ADC PARKS & GREENSPACE ARBORICULTURE

PLANNING APPLICATION: FP/168/14/T

ADDRESS: The Southdown 133 Felpham Way Bognor Regis PO22 8QI

BRIEF DESCRIPTION: Fell to near ground level 2 No failed Conifer stumps, fell 1 No Conifer hedge to near ground level, crown lift to 4m above ground level 4 No Hawthorn trees and remove stumps of 2 No Conifers including surface roots.

MAP Ref: 25432

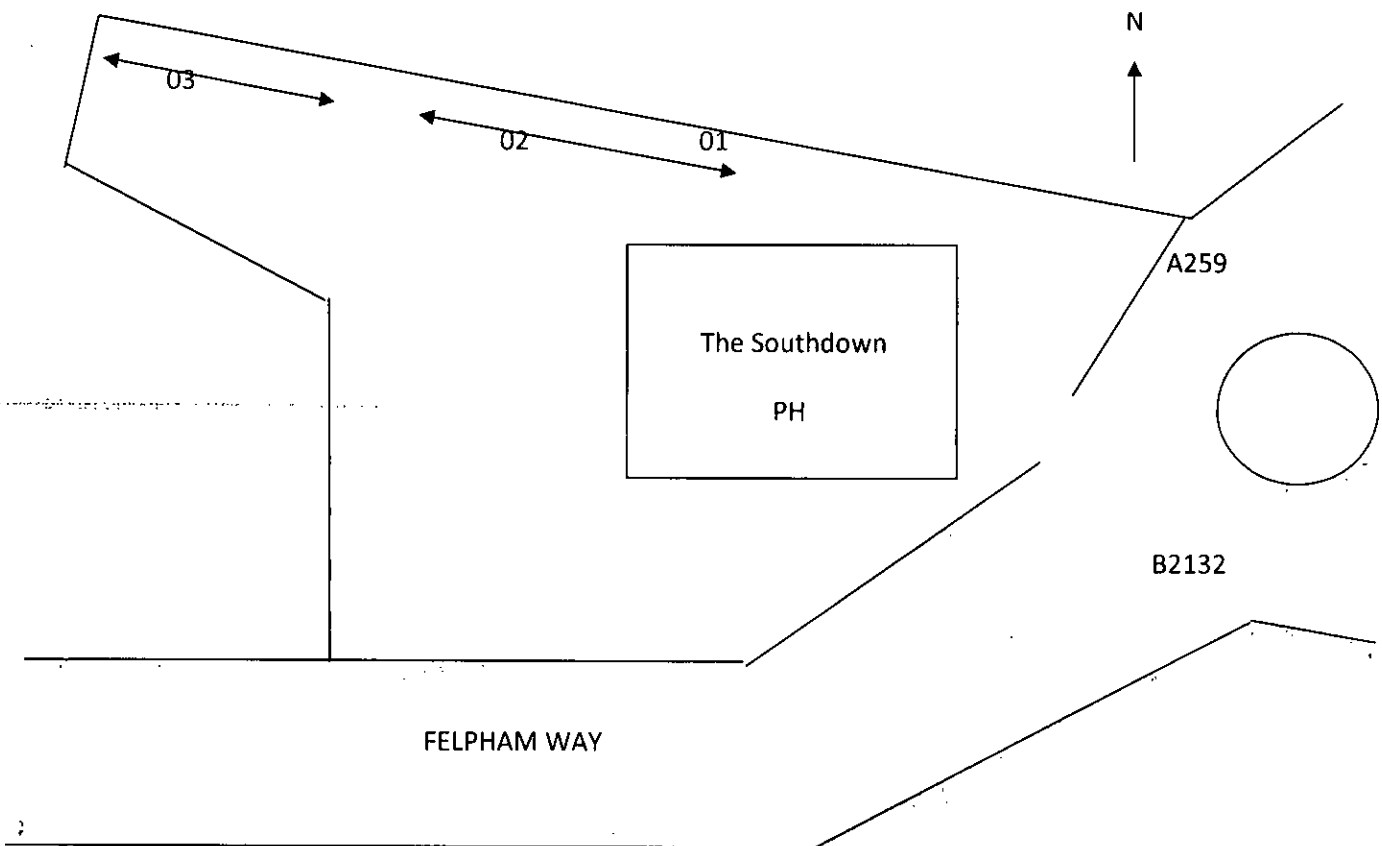
- The conifer hedge is made up of 7 clear individuals (the true number of individuals may differ slightly, as the growth habit has made it difficult to distinguish between a few of the trees). This hedge line has clearly had some historical management to keep the hedge form, however it appears this has not been adhered to at some point as the lateral extension growth and large gaps appearing between the lateral branches would indicate that this hedge line did begin to revert back a tree form at some point.

- The result of this lack of management is that the aesthetic value has been greatly diminished and the function of this hedge as a 'screen' for the boundary line is now questionable. Further training via pruning would improve the current form of this tree line somewhat; however the chance to revert this line to a functional hedge line has been missed.

- The application has also requested a 4 meter crown raise of a line of early mature Hawthorn trees spanning in a linear line along the northern boundary. These trees southern edge are also abutting the Public house car park. The proposed crown raise will be limited to this southern side and is clearly designed to allow full vehicular access to the car park below. From the site inspection it is clear that there has been previous crown lifts on the outlined hawthorns alleviate the problem of contact between vehicles and branches. This operation is likely to change the appearance of the outlined hawthorns; however it is unlikely to have a significant impact on the vitality/retention span of these trees. Also the aesthetic value is unlikely to be altered by such an activity.

- As for the failed conifer stumps, as they are confirmed to be dead they can felled without consent from the Local Authority. As these stems had no active TPO, there will not be a requirement to replant a tree in the same location.

- As the outlined conifer hedge line has poor arboricultural merit, low retention span, and it is unlikely that any form of management would restore the habit to a hedge form; **I would have no objection to the felling of this hedge line.**
- As for the crown lift of the Hawthorn line, this is remedial operation that will ensure no damage is caused to the hawthorn trees from interference with vehicles using the parking area. **I would therefore have no objection to the 4 meter crown raise** of the southern side of the outlined hawthorn trees.
- **I would also have no objection to the felling of the 2x dead conifer stems**, as this would have no detrimental effect on the surrounding landscape and/or the aesthetic value.

Branches found within the clearance height having diameters greater than **100mm** should be shortened and no more than 15% of the leaf bearing growth of that branch should be removed to facilitate the unobstructed free passage of vehicles and pedestrians.
